19 June 2015

Development Referral No. DN15/0007

Proposal: Sutherland Hospital Redevelopment (SSD 6847)

Property: 126 Kareena Road, Caringbah

01.06 LANDSCAPE DRAWINGS

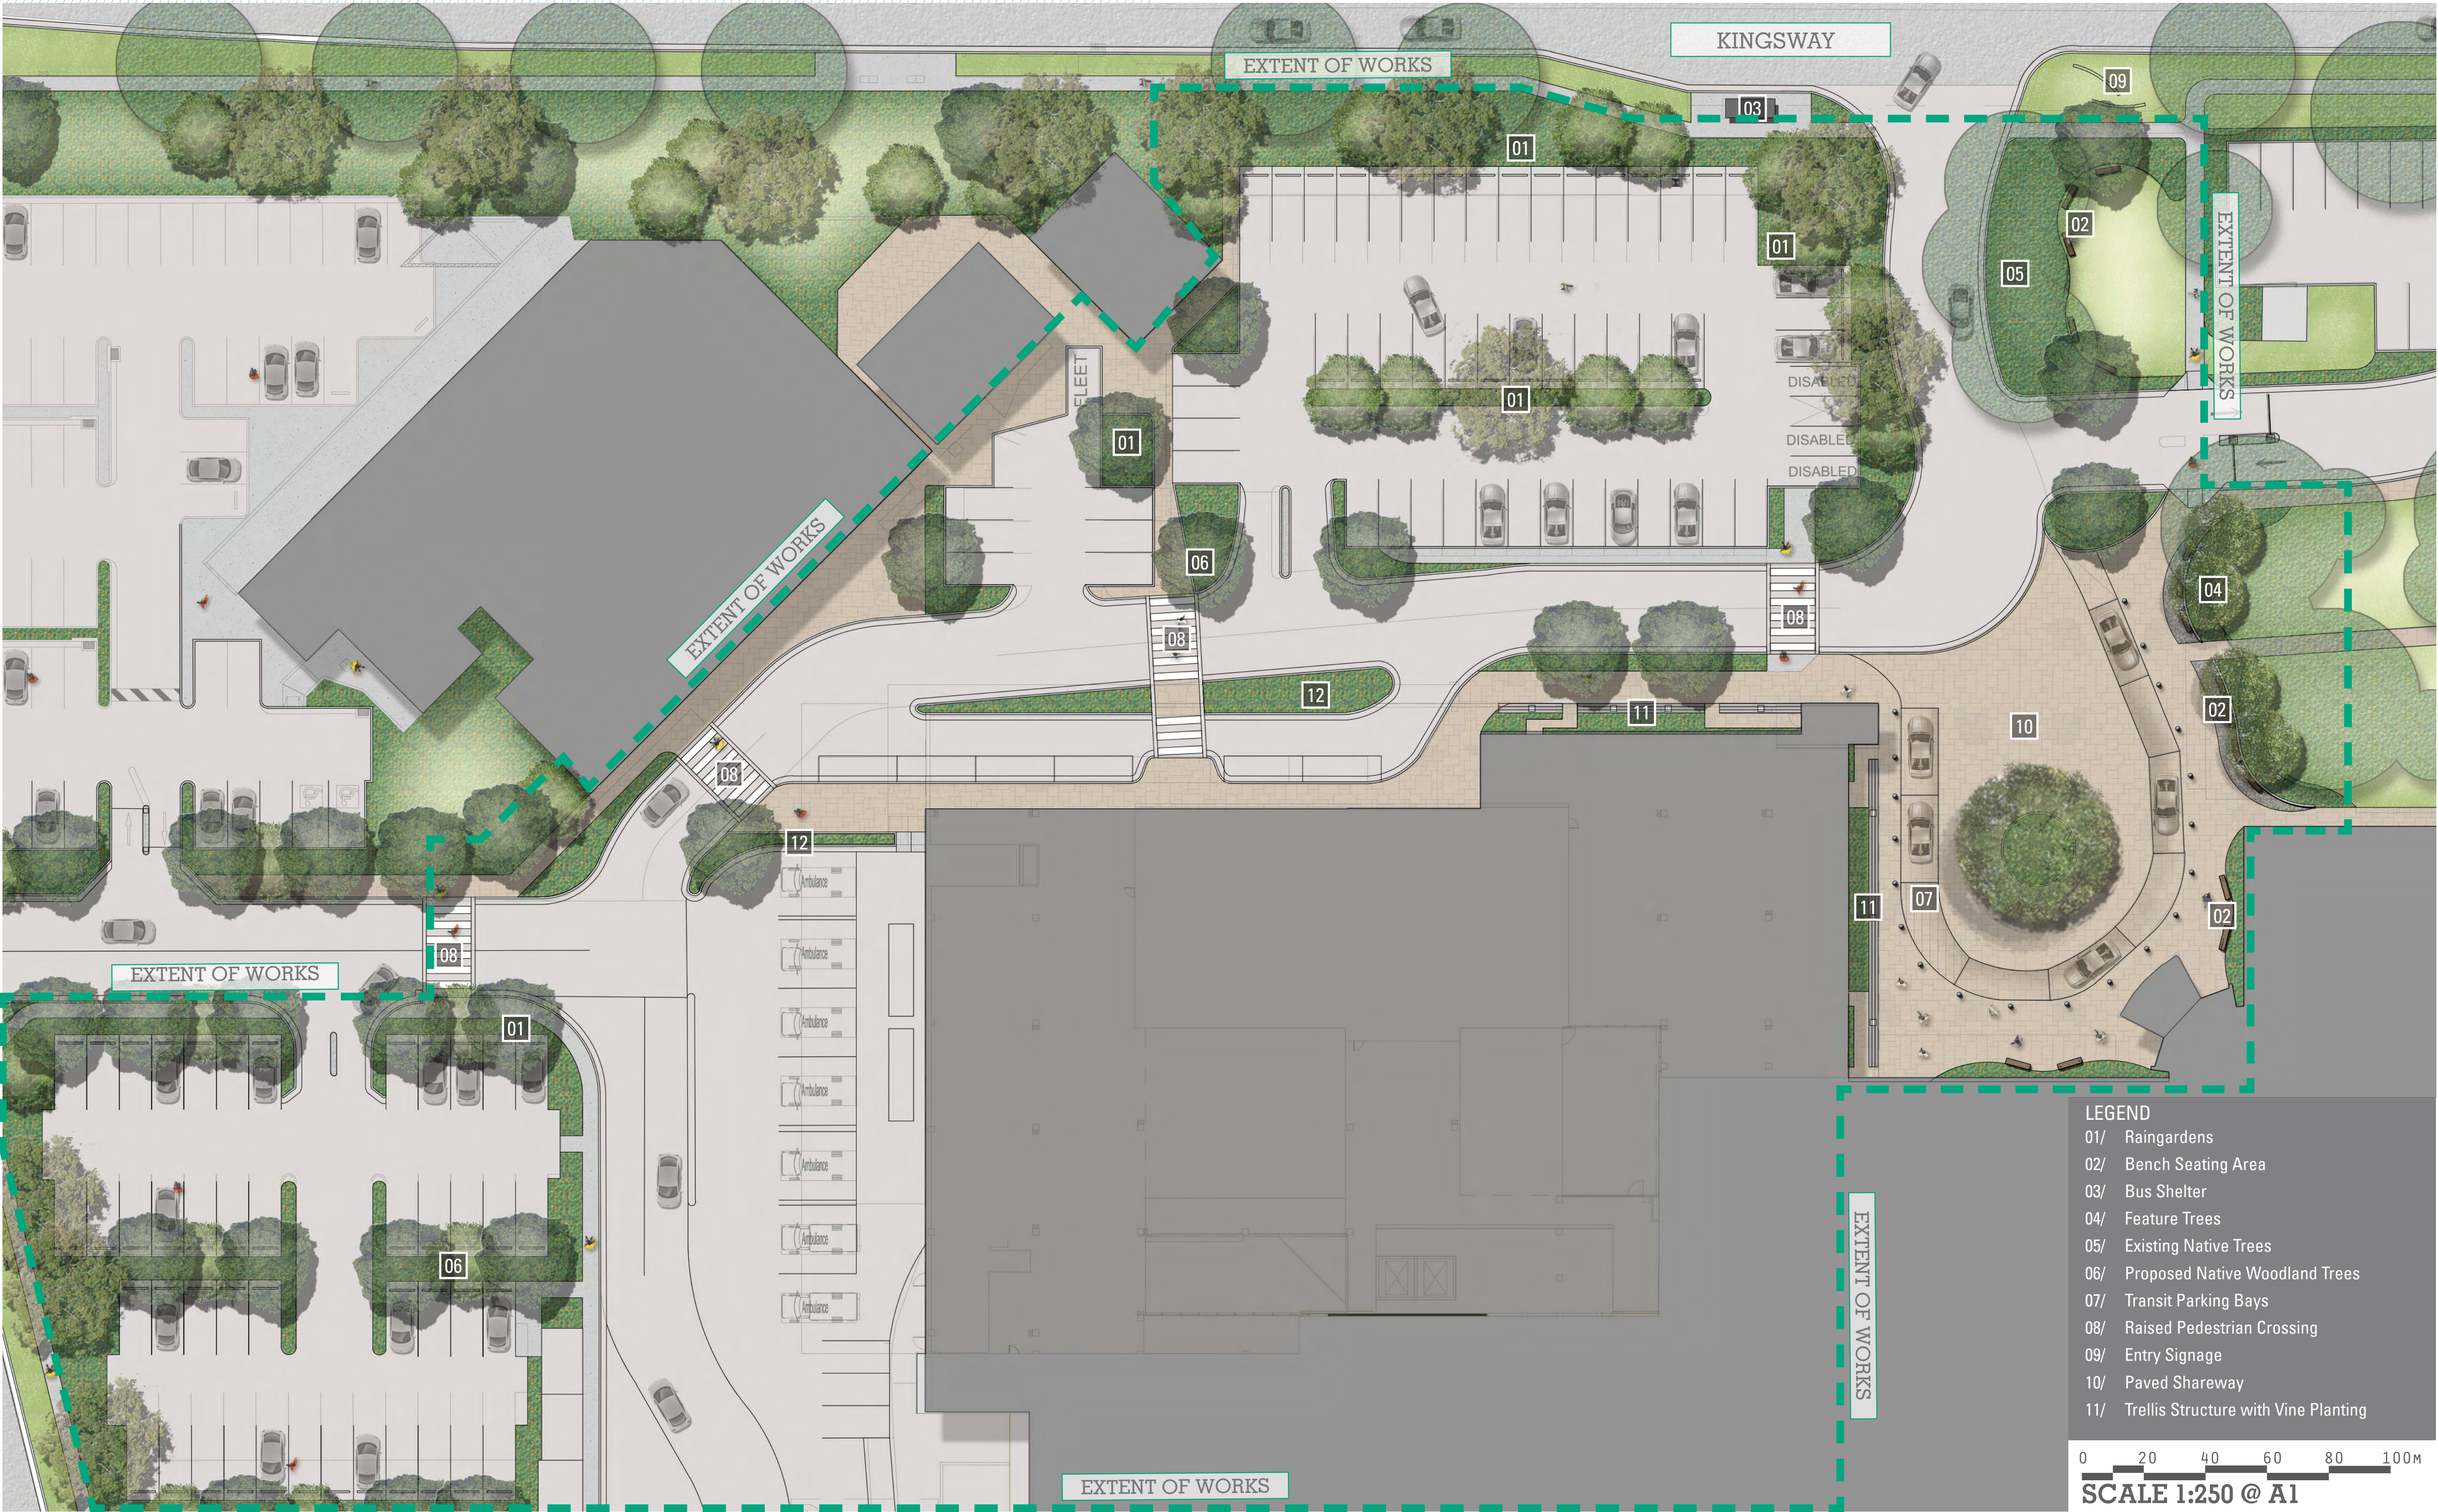
It is not clear whether any tree planting is proposed along the Kingsway frontage to the east where the new car park is currently being constructed and where a number of existing trees have been removed. Council requests that indigenous tree planting be continued along the eastern section between the front boundary and the car park to provide shade and screening to the car park and to strengthen the landscaped setting along the Kingsway frontage.

Further, it is unclear from the documentation as to whether a rain water proposed. The use of harvested water and a water-efficient irrigation is encouraged by Council for establishment of the plantings.

TREES + SHRUBS

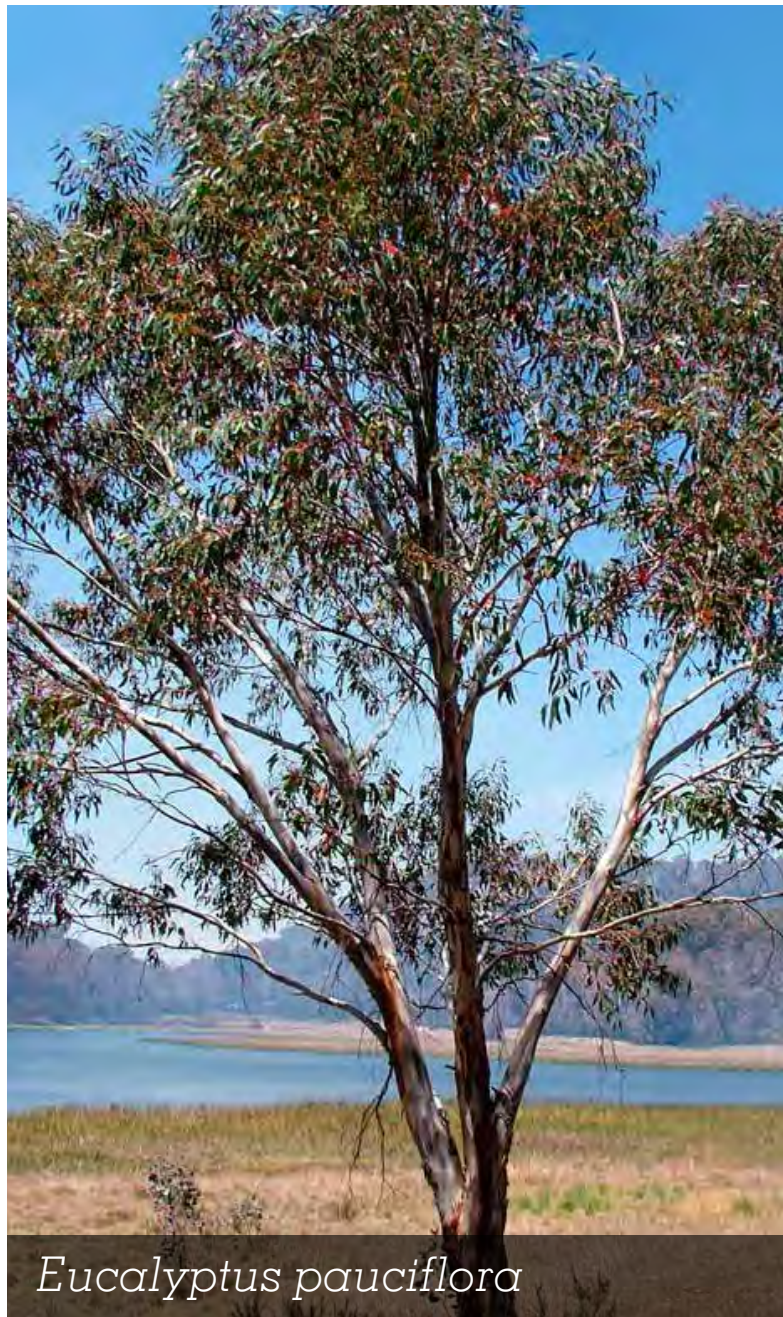
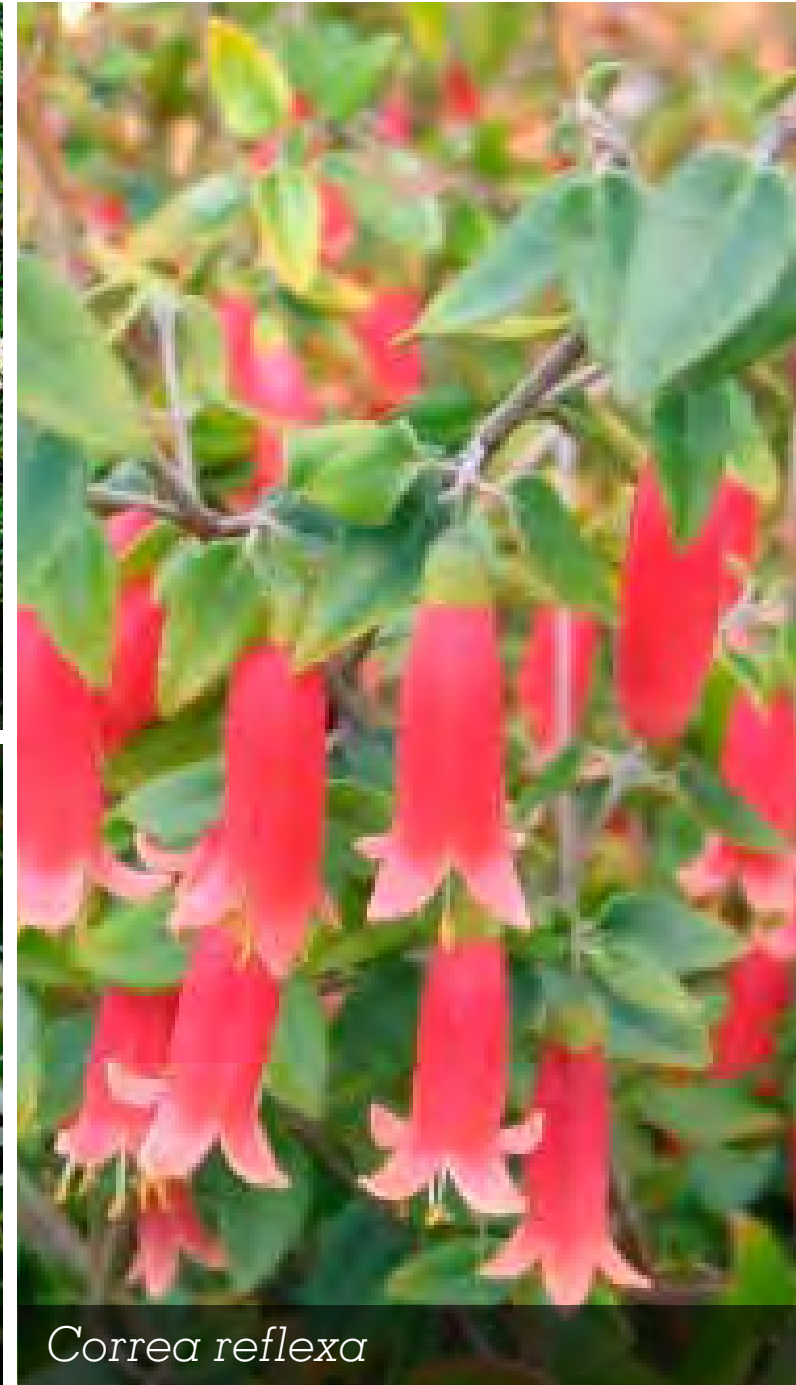
The hospital is located in Greenweb 'Restoration' zone (maps available on Council's website) which requires that all new trees must be 100% indigenous species and understorey plantings must be 50% indigenous species. The proposed plant schedule does not comply with this requirement – species such as *Eucalyptus baueriana*, *E. pauciflora* (Snow Gum), *E. viminalis* (Ribbon Gum) *Hymenanthera dentata*, *Melaleuca ericifolia* and others are not indigenous to this site or to the Sutherland Shire. The landscape architect should refer to the Native Plant Selector on Council's website (www.sutherlandshire.nsw.gov.au) and search for Native Plant Selector) for suitable species.
